4th June 2019

Single storey side extension. Single storey rear extension. Conversion of flat roof to pitched roof above kitchen to create habitable roofspace. Conversion of roofspace to habitable use to include a rear dormer. This application affects the character and appearance of the Arundel Conservation Area. The application affects the setting of a Listed Building.

62 Maltravers Street Arundel

Thank you for your internet representation made on 3rd June 2019 which has been recorded as '**no objection**' with the comments as follows:

PROPOSED ELEVATIONS

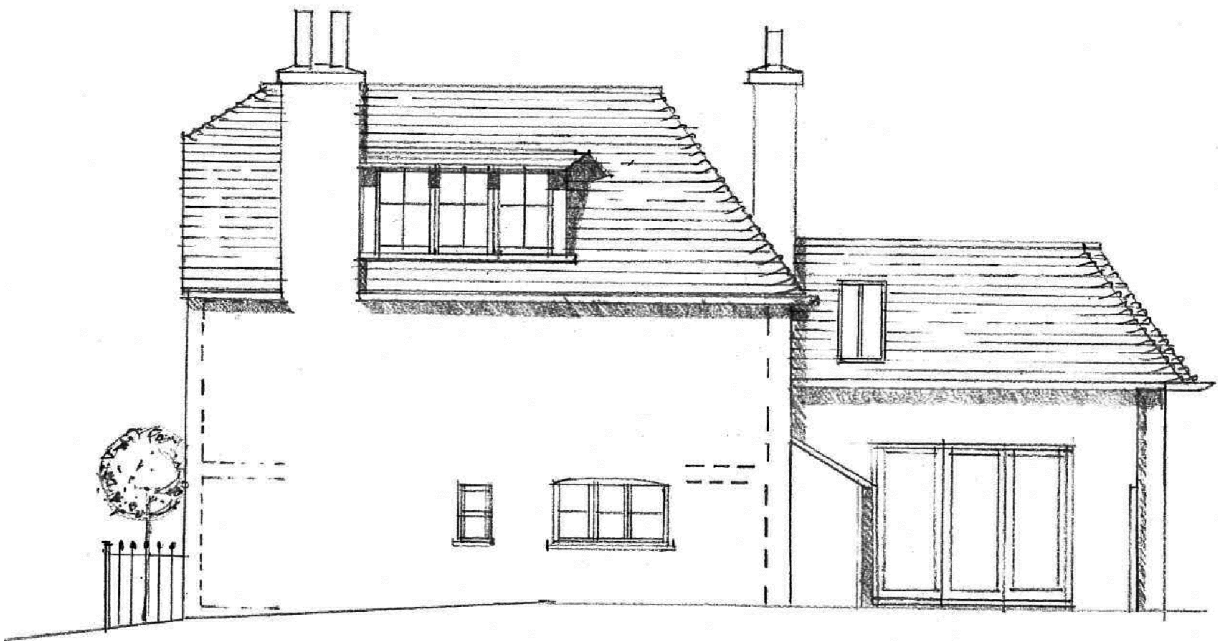
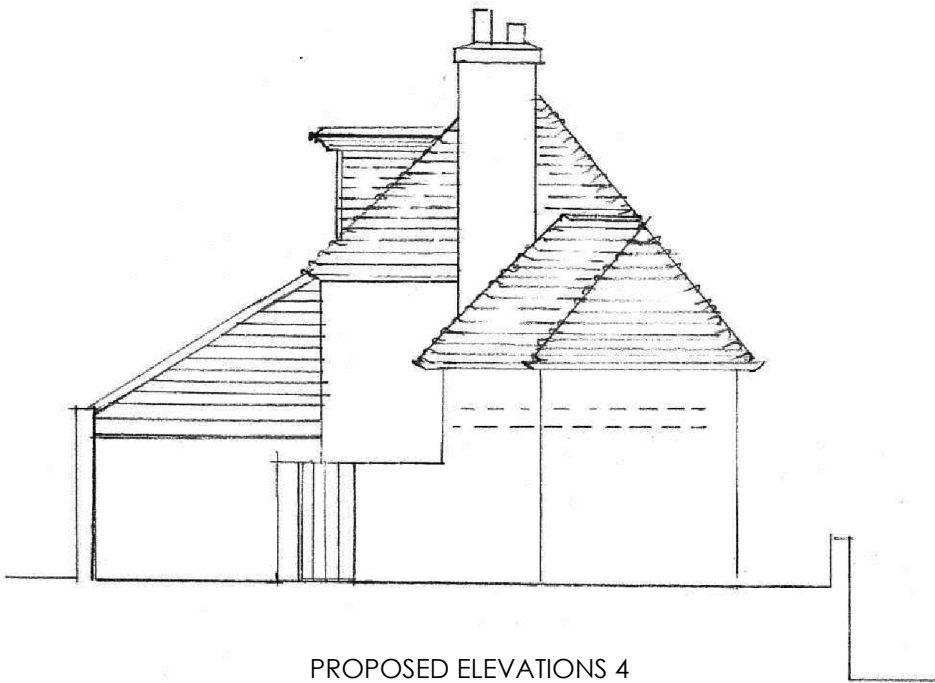
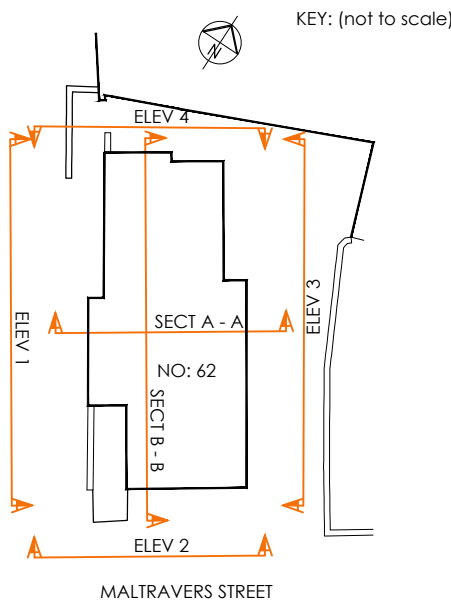
The proposed alterations and extensions are well designed. If undertaken using the materials indicated in the Agent's Design and Access Statement and application form the proposals will represent an enhancement to the appearance of the existing building and the conservation area. It is suggested that conditions be attached to any planning permission requiring: (1) samples of bricks and tiles to be submitted to the LPA (2) roof lights to be conservation style (3) precise details of all new timber doors and windows to be submitted to the LPA
